DEVELOPMENT REVIEW COORDINATOR
POST APPROVAL PROJECT CHECKLIST

Project Name: One Joy Place - 12 condos new build

Project Name: Onejoy Place Condominium - Twelve Unit Residential Building
Project ID: 2017-103 (Subdivision and Site Plan)
2017-128 (Conditional Use Inclusionary Zoning)
Address: 1 Joy Place CBL: 045 E049001
Applicant: Onejoy Place LLC
Planner: Jean Fraser

One Joy Place - Final Traffic Comments

DATE: 3/7/2017  
SCALE: 1" = 10'  
DESIGNED: MTW  
JOB NO.: 1704  
FILE: 1704-BASE.DWG  
SHEET **C-3.0**

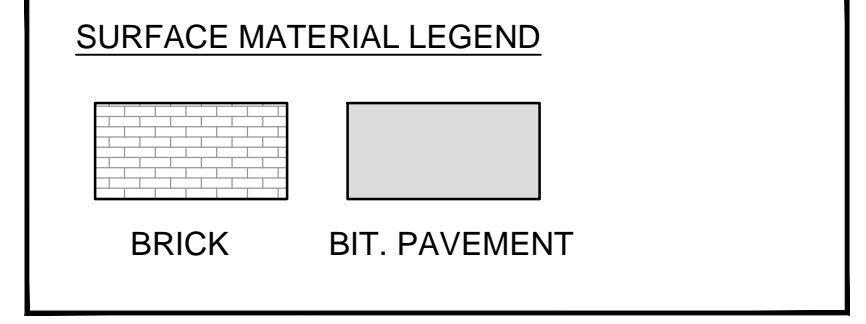
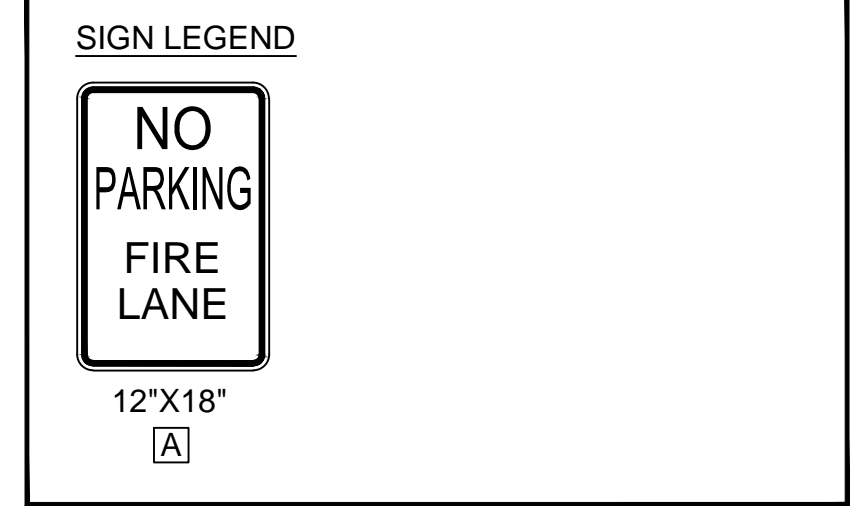
I am OK in general terms with the location and type of the lighting, but the details don't quite "add up".

It appears that you have moved up the lights on the back of the building so that the light hitting the ground is less, but I am still concerned about the glare of the source light.

Regarding the bollards, why has the first bollard (nearest Brackett) gone up to 4.5? Also the "watts" level is still listed at 24 and I would have thought that would be reduced.

I think the best way forward on this is that I will approve this photometric subject to a condition on the main building permit that provides for a review of the lighting prior to the CO, and if there is glare that impacts a neighbor we will ask for a lower level bulb to be substituted (or a shield if the bulb change is not possible).

Drawing file: Submitted plans / Joy Place C-3.0 SITE LAYOUT PLAN.pdf

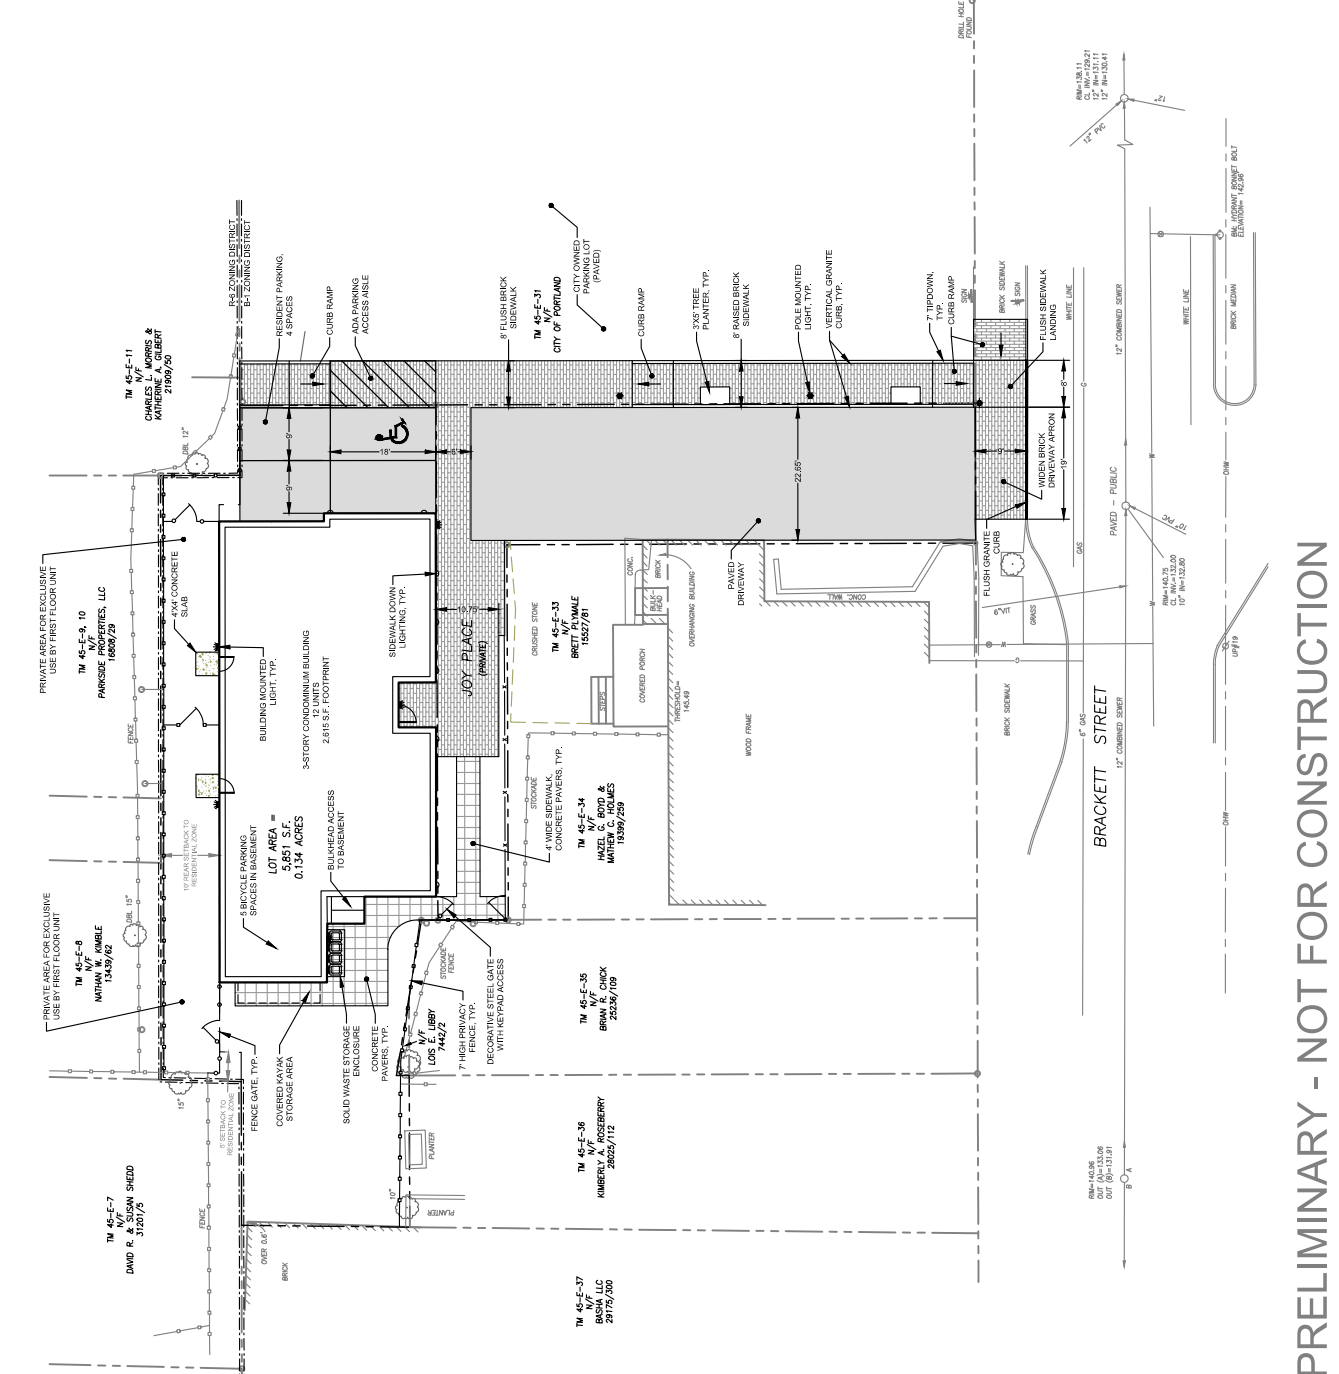
- It is my understanding that parking for the abutting property will be provided in the rear of the building and along Joy Place. A parking layout plan shall be provided that illustrates how the three vehicles will park and circulate into and out of the spaces. I'm concerned about the parking area along Joy Place and encroachment into the driveway access/egress area (and ensuring only one parallel vehicle parks).

- I do not recommend backing maneuvers from Joy Place onto Brackett Street and thus the applicant should demonstrate that vehicles can turn around on site.

- The applicant should note how the tandem parking spaces will be managed.

Status: The applicant has revised the plan and provided information on abutting parking conditions that I find acceptable. I have no further comment.

Status: The applicant has provided vehicle turning template information. The site plan allows for vehicle turnaround maneuvers and therefore I have no further comment.

Status: The applicant has provided information on parking management. It is my recommendation that a condition of approval note that On-Site Parking Space # 1 be designated to a specific residential unit and On-Site Parking Spaces #2 and #3 be designated to a single residential unit (to prevent vehicle blockage issues).
